ALBUQUERQUE
AQUAPONICS
512 YALE ST SE
Albuquerque, NM 87108

Historical Causes of Drainage / Elevation Problems Concerning 512 Yale SE, 2206-2210 Garfield SE and Adjoining Properties

Re: Brewstiller
500 Yale SE
Traffic Circulation Layout
Architect's Stamp dated 02-05-16 (K15-D099)

Based upon the information provided in your submittal received 08-31-16, the above referenced plan cannot be approved for Building Permit until the following comments are addressed:

C5 SCHEMATIC SECTION AT TRENCH DRAIN

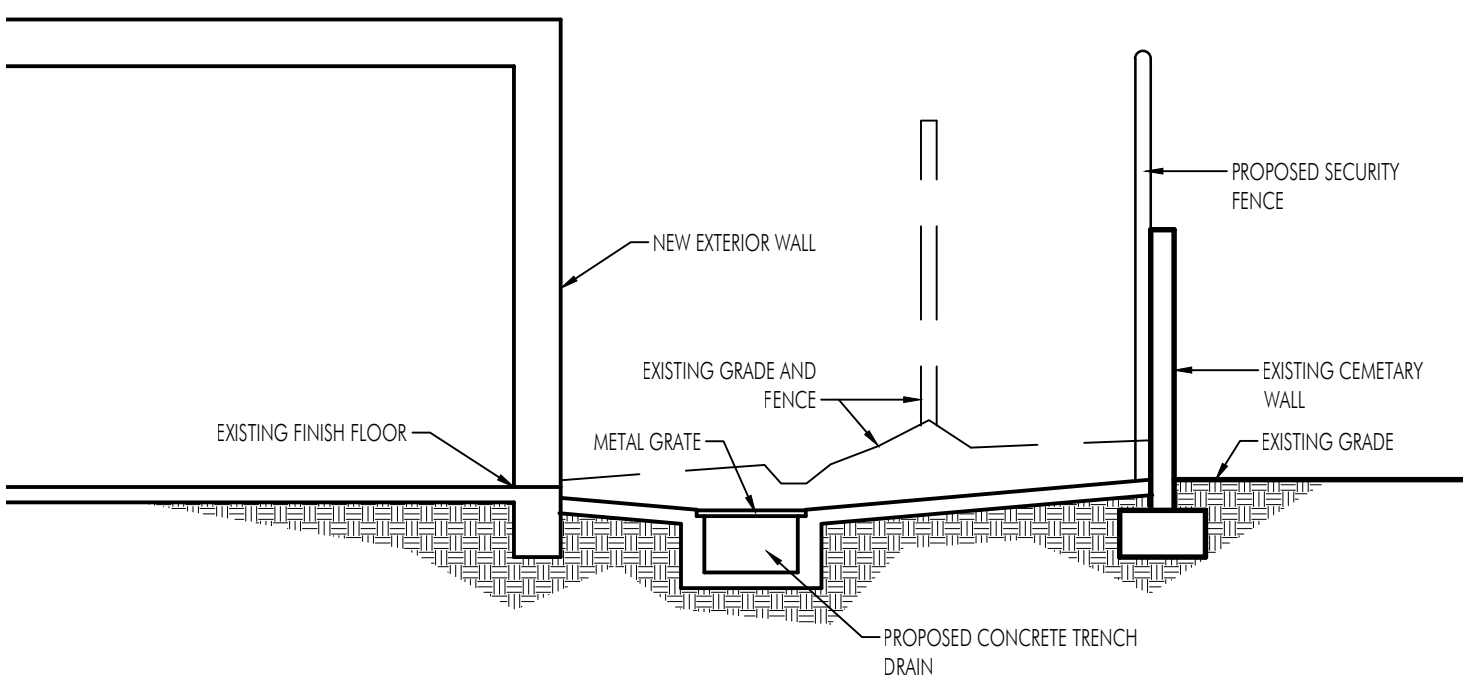
- I cannot tell where the property line is. There are 2 references.
The Property Line for 512 Yale lies right in the middle of the utility easement- The note calling out the CMU wall on cemetery property line should be revised to say "CMU WALL ON CEMETERY PROPERTY"

- What is the meaning of the dash-dot-dash lines? There are 3 lines and it is not clear
DASH DOT LINES REPRESENT SECURITY FENCING ON BOTH PLANS- WE ARE PROPOSING TO MOVE THE EXISTING FENCE ON YALE PROPERTY TO THE CEMETARY WALL TO CUT OFF THE EASEMENT FROM THE ALLEY

SHEET NO:
A1.2

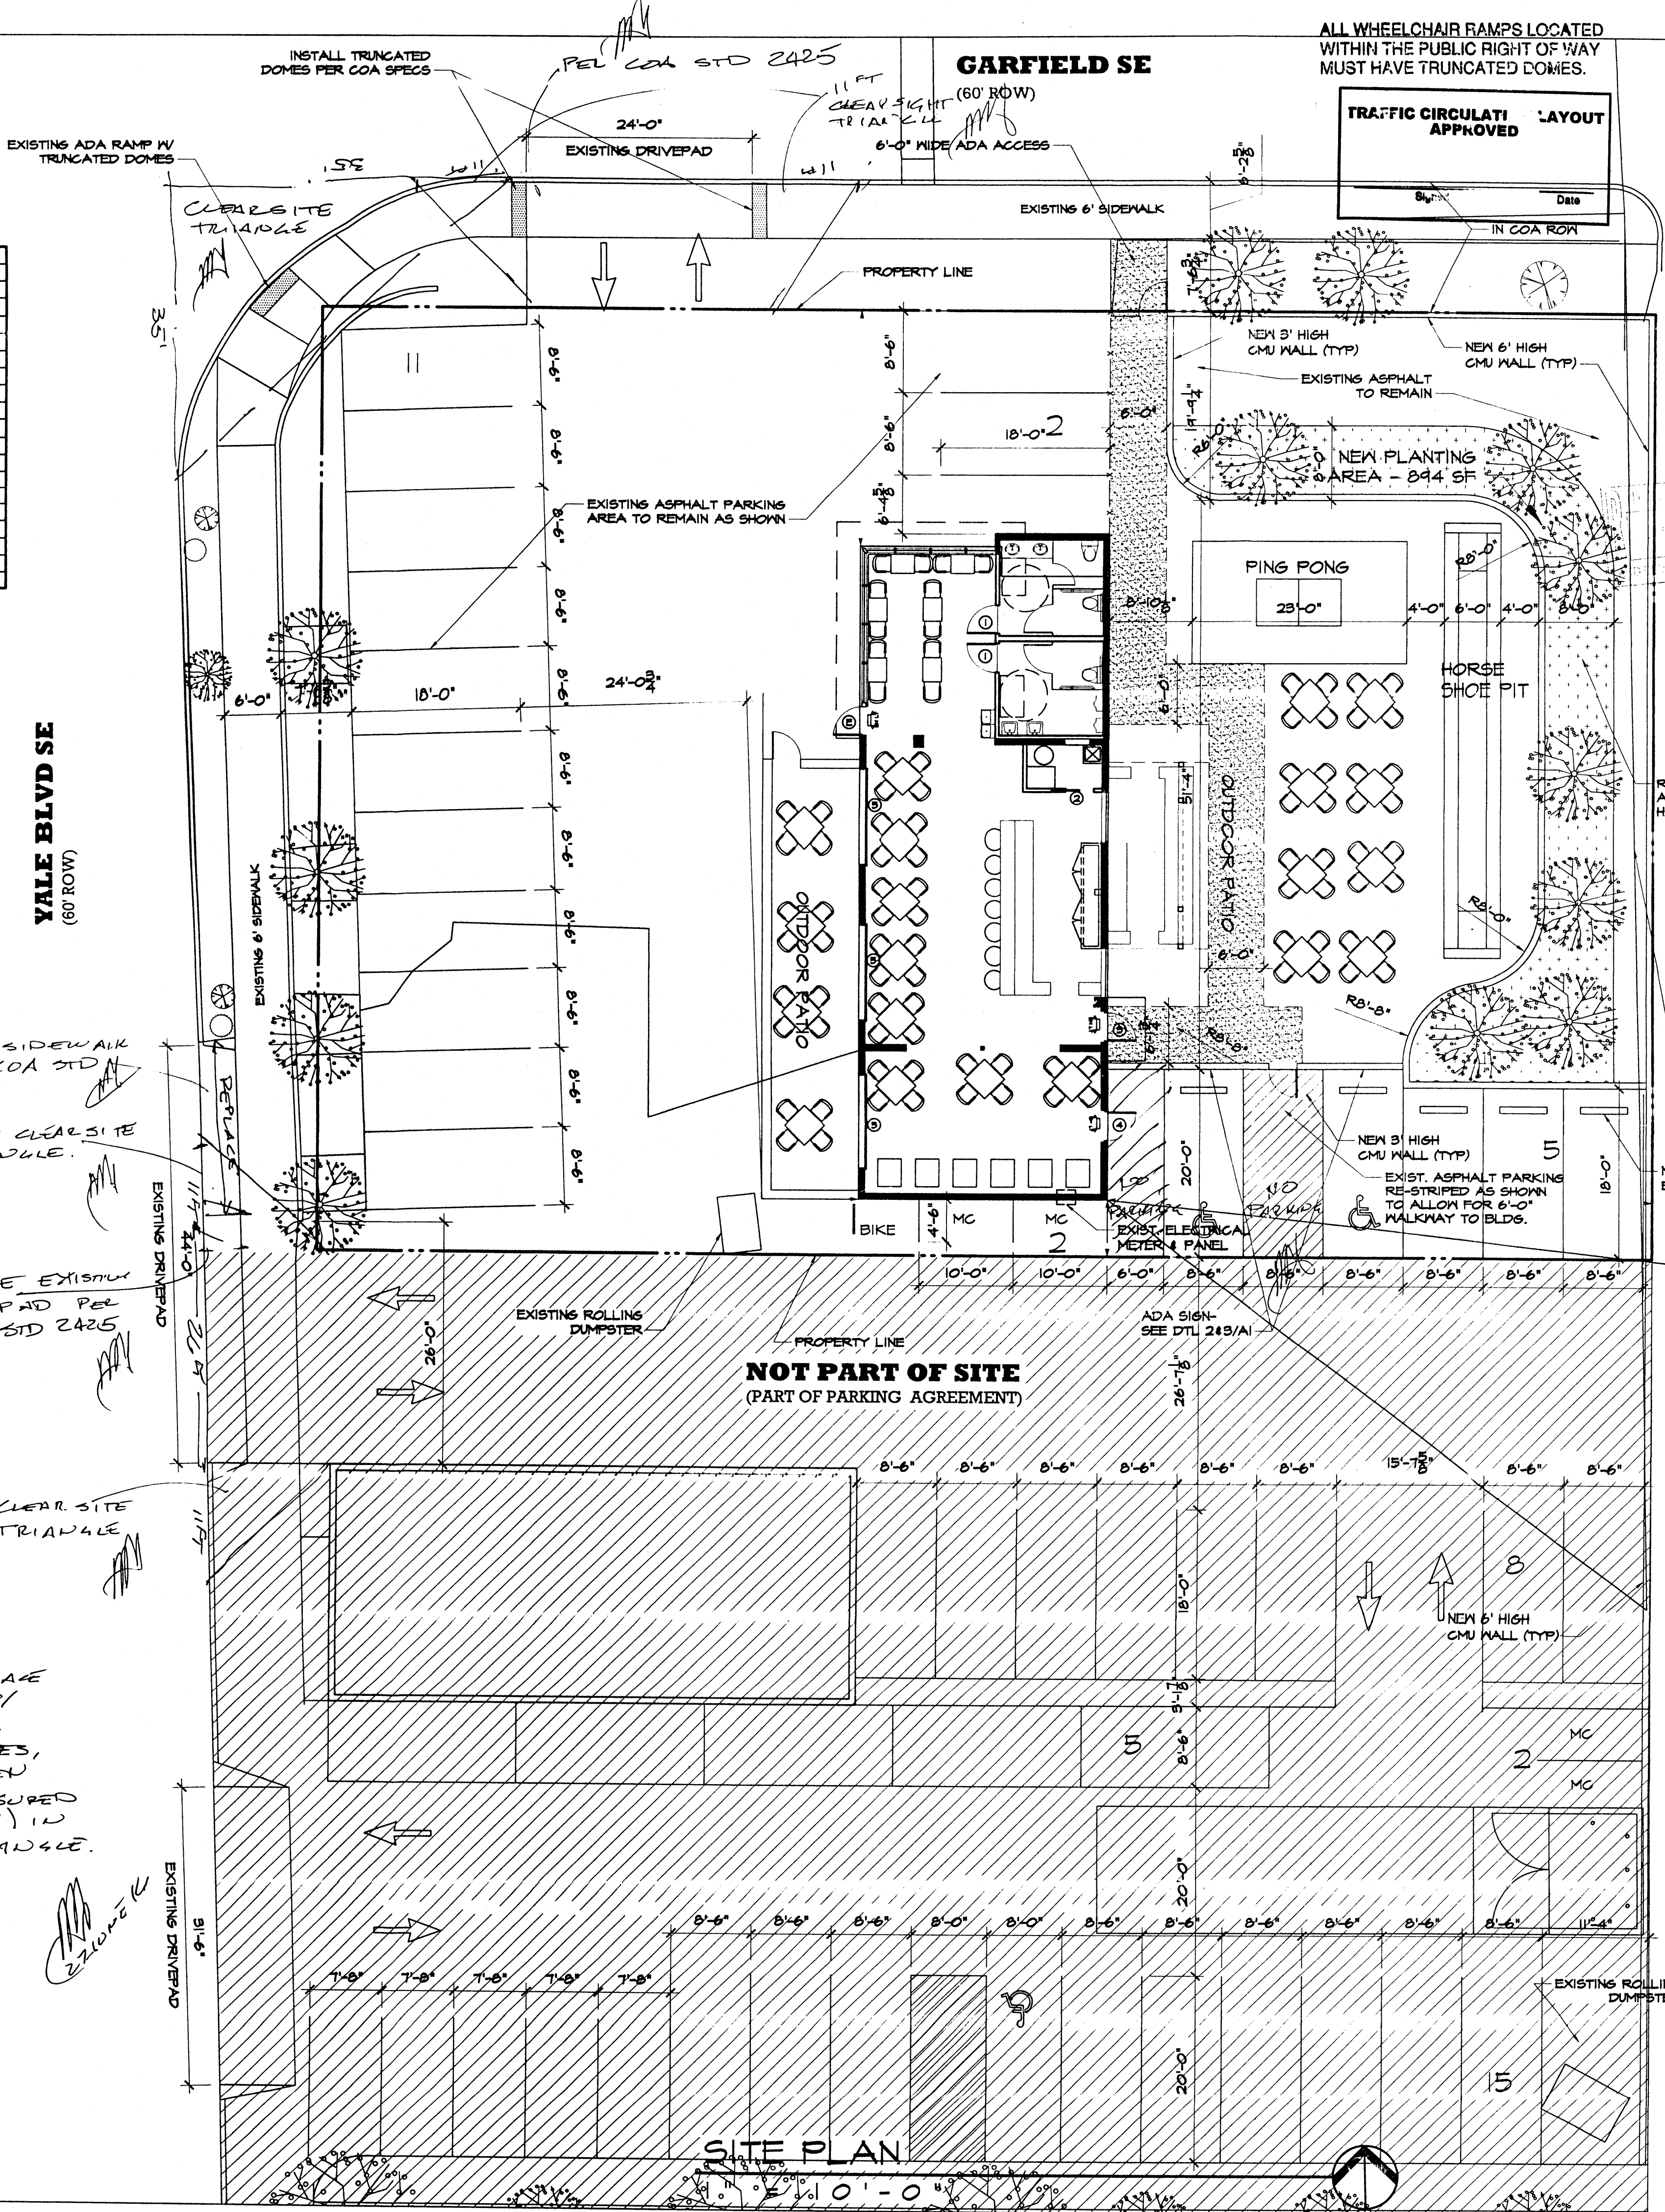
1. The ADA access aisles shall have the words **"NO PARKING"** in capital letters, each of which shall be at least one foot high and at least two inches wide, placed at the rear of the parking space so as to be close to where an adjacent vehicle's rear tire would be placed. (66-1-4.1.B NMSA 1978)
2. The existing curb cut on Yale Blvd must be reconstructed to match the existing dimension of the drive aisle on the property. It must be replaced with sidewalk and curb & gutter. A build note must be provided referring to the appropriate City Standard drawing.
3. Add a note stating "All broken or cracked sidewalk must be replaced with sidewalk and curb & gutter." A build note must be provided referring to the appropriate City Standard drawing.
4. Please include two copies of the traffic circulation layout at the next submittal.

Attached is the revised TCL per your letter of September 15, 2016.
I added the 'No Parking' in the ADA access aisle, re-drew the drive pad
on Yale to be 26' wide, added notes to do the curb and gutter to COA
Standards and added a note regarding broken or cracked sidewalk to be
replaced.
